**Consultation Response from Mike Hibbert,  
KC Waste Strategy( Refuse & Recycling)**

**2024/92031 Headlands Works, Headlands Road, Liversedge, WF15 7NT**

**Outline application for erection of residential development, adoptable road and public open space**

**Responding Ref: WPN 24- 022**

Development Proposals

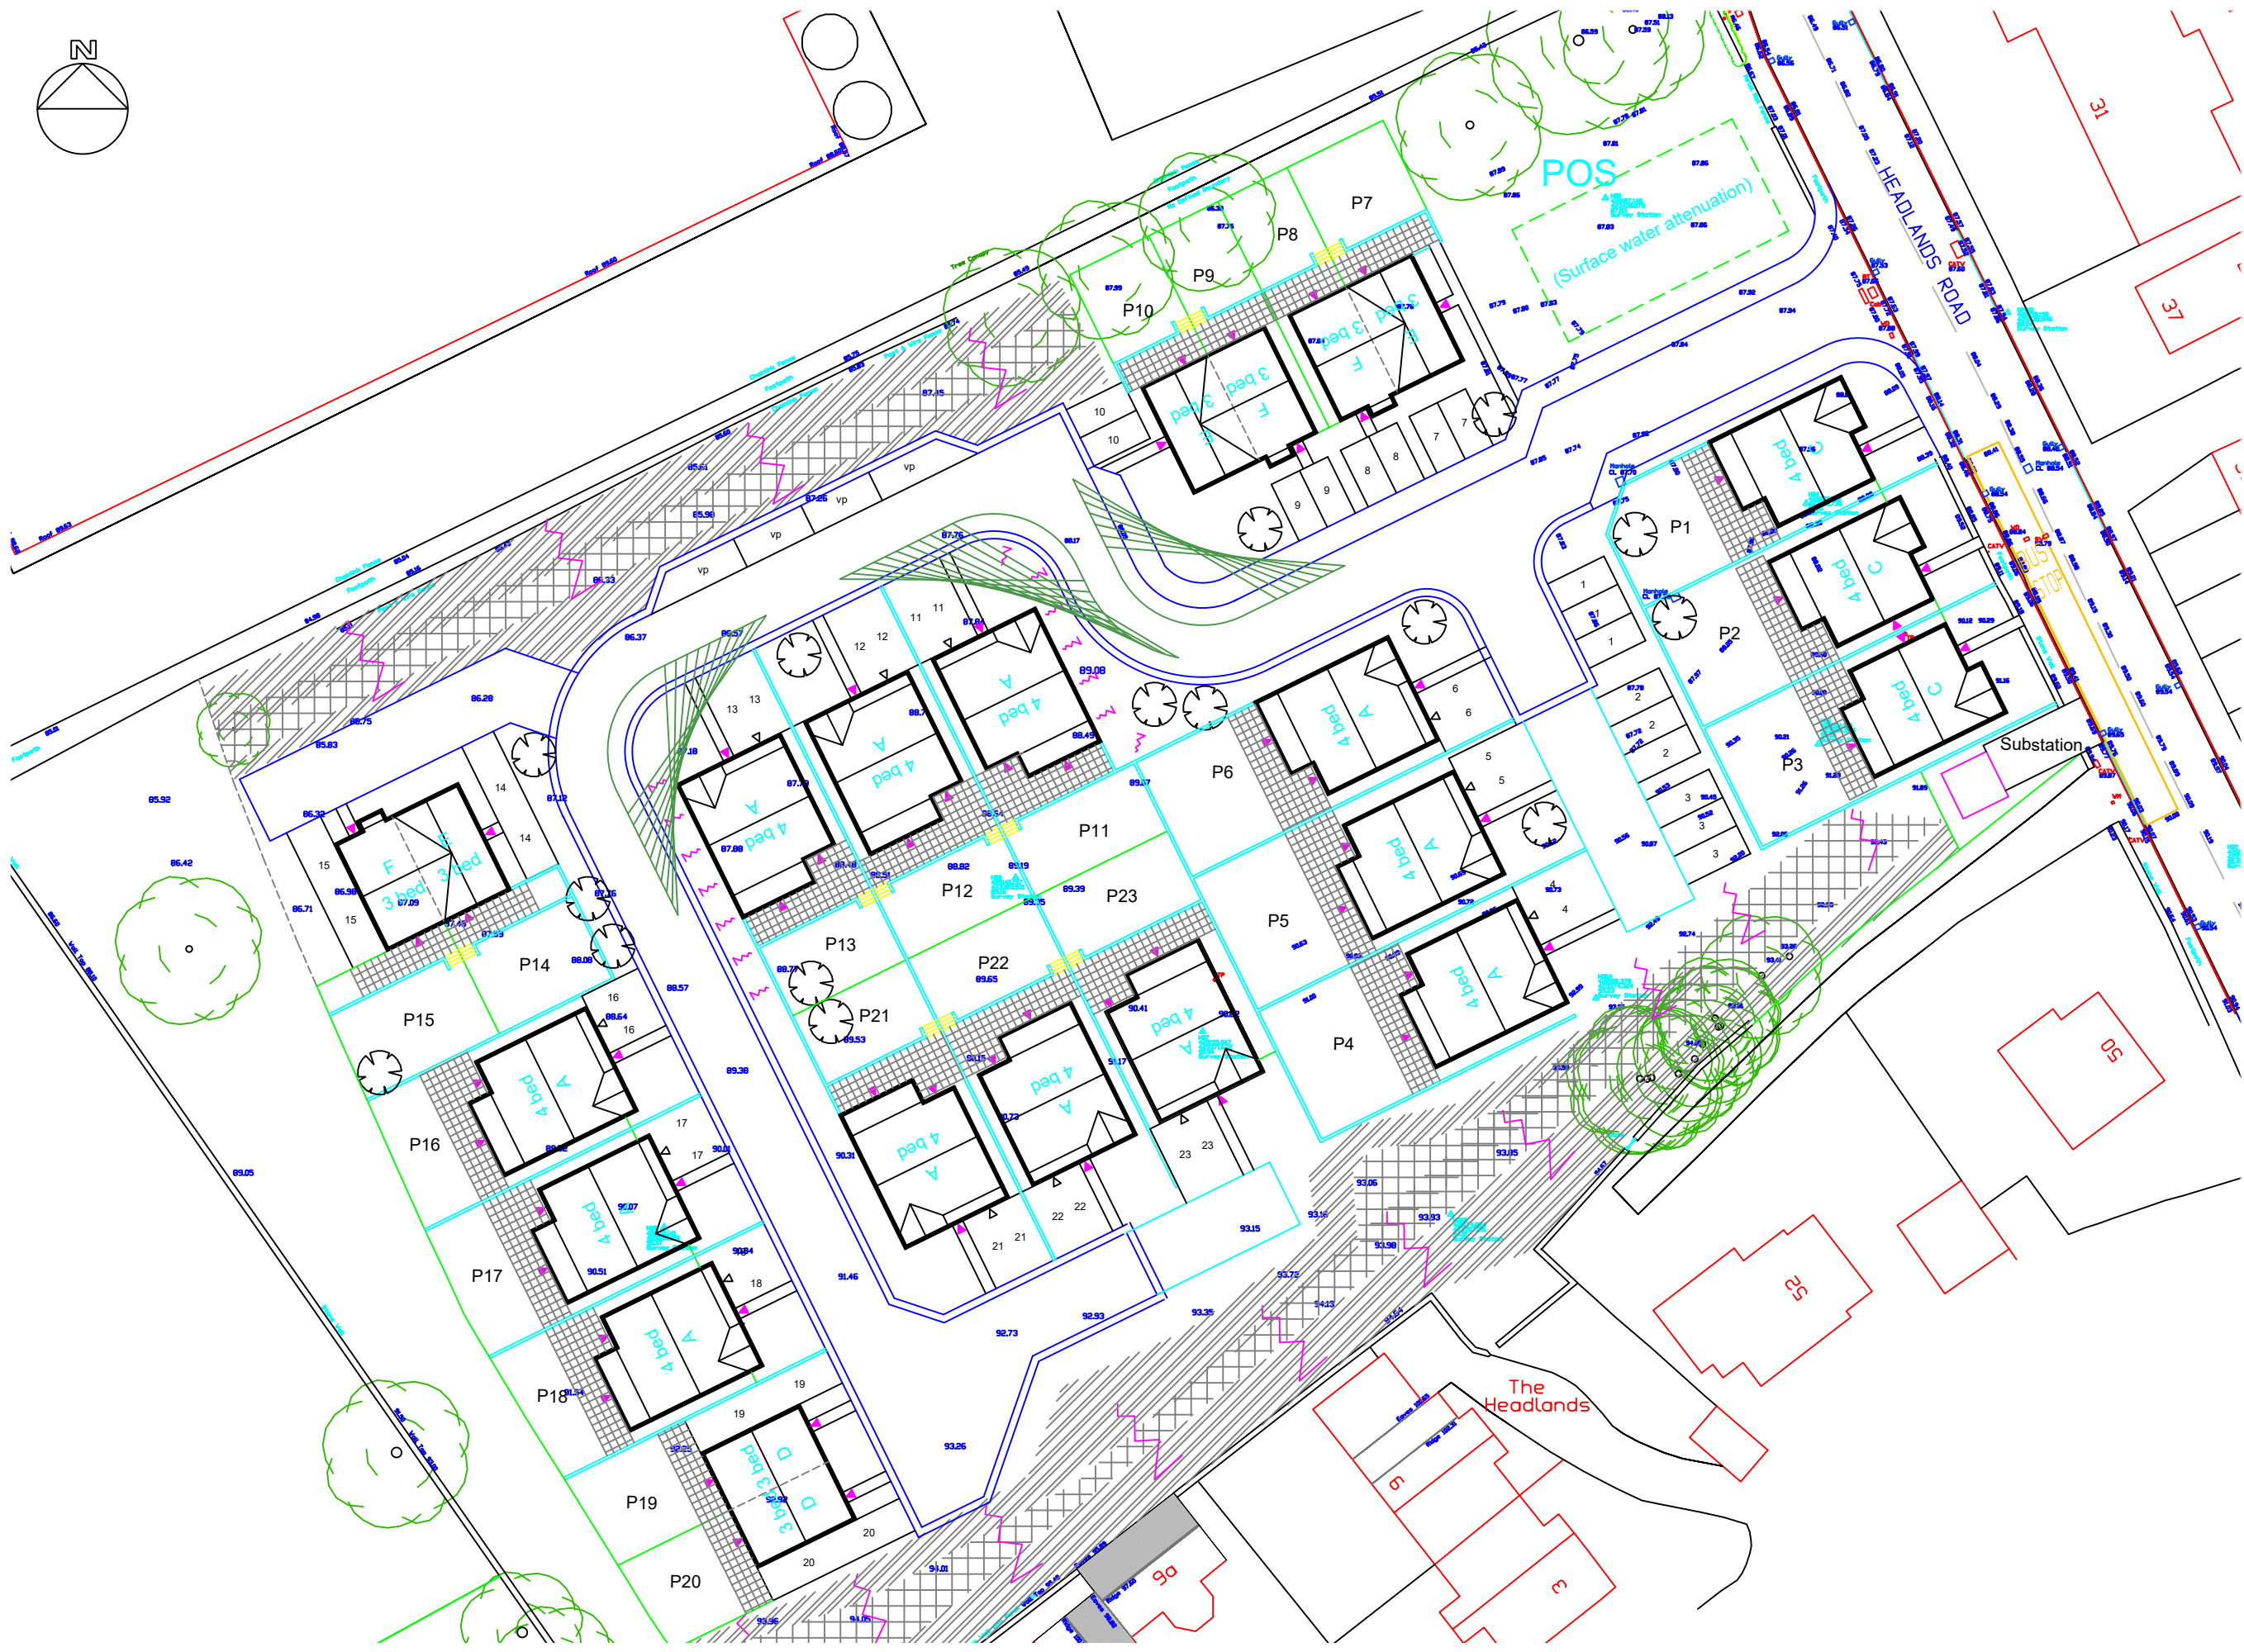
- For Plots 3, 4, 5 and 23 bins will need a Bin Collection location adjacent to the adopted highway at the end of the turning head.
- Angular road shapes such as that shown adjacent to Plots 7, 10, 21 and 22 present difficulties for street cleaning, are a common area for litter and dirt to accumulate. This needs to be properly considered in any detailed proposals

- The turning head in front of Plots 19 and 20 must be demonstrably sufficient for an 11.22m refuse collection vehicle. **Active measures should be taken to prevent parking in the turning head as otherwise an RCV would have a long reverse manoeuvre, that is a recognised safety risk and is not acceptable.**
